## Application for a Non-Material Amendment Following a Grant of Planning Permission

Conversion of existing garage to habitable room and alterations to the existing garage door to bay window. Construction of a single storey front extension, single storey rear extension and two storey side extension.

22/01517/HHA

DRAWING NAME
PROPOSED ROOF PLAN

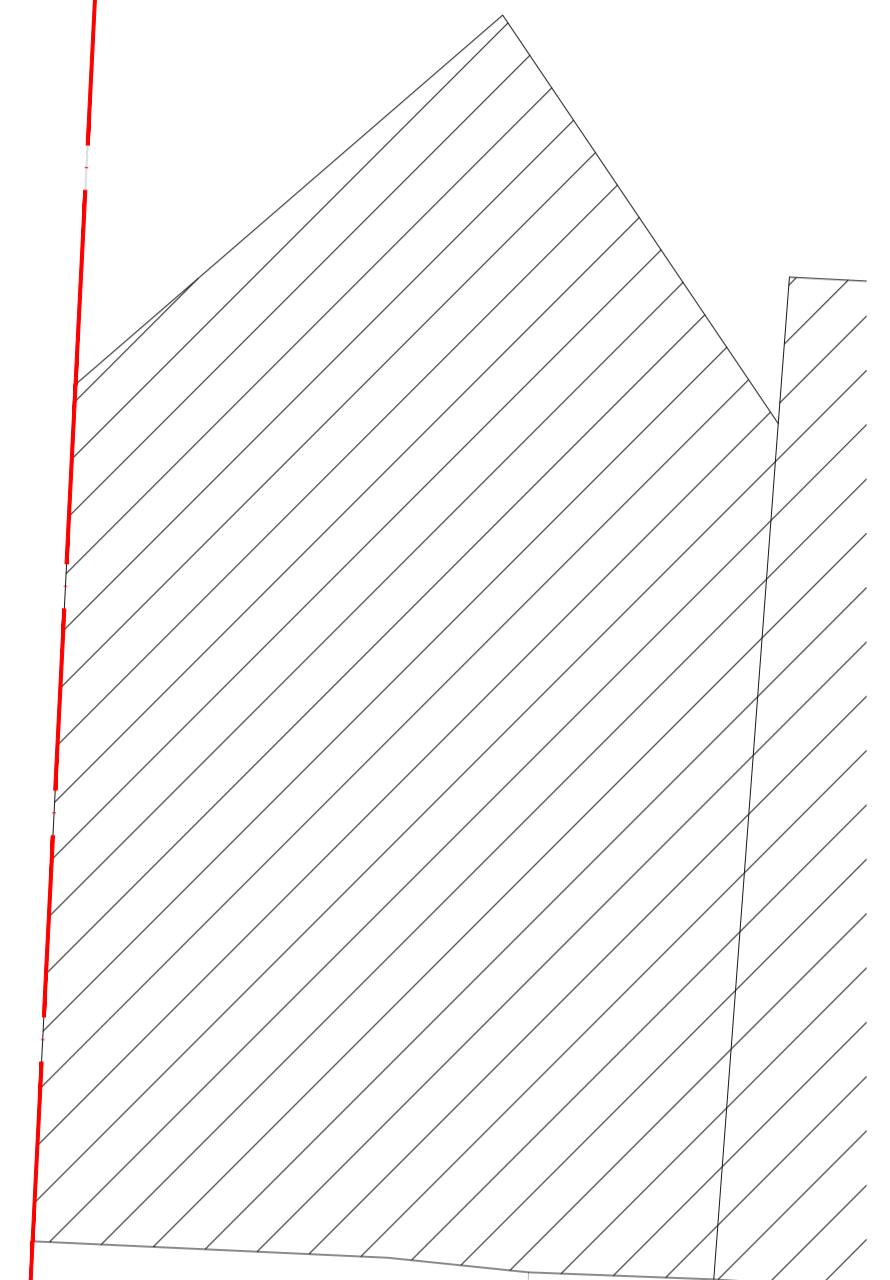
New proposed sidelight glazing panel adjacent to previously approved North side elevation door, and the addition of 1 No. new rooflight above the stairwell on the North elevation.

Adding a roof light to the North stairwell will enable the space to be naturally ventilated and allow some natural light into the location of the stairs. Likewise, the addition of a sidelight glazing panel to the previously approved door on the North elevation will provide some natural daylight into the boot room on the ground floor. In respect to both amendments, these are both in locations which are non-habitable spaces; the boot room and the stairwell.
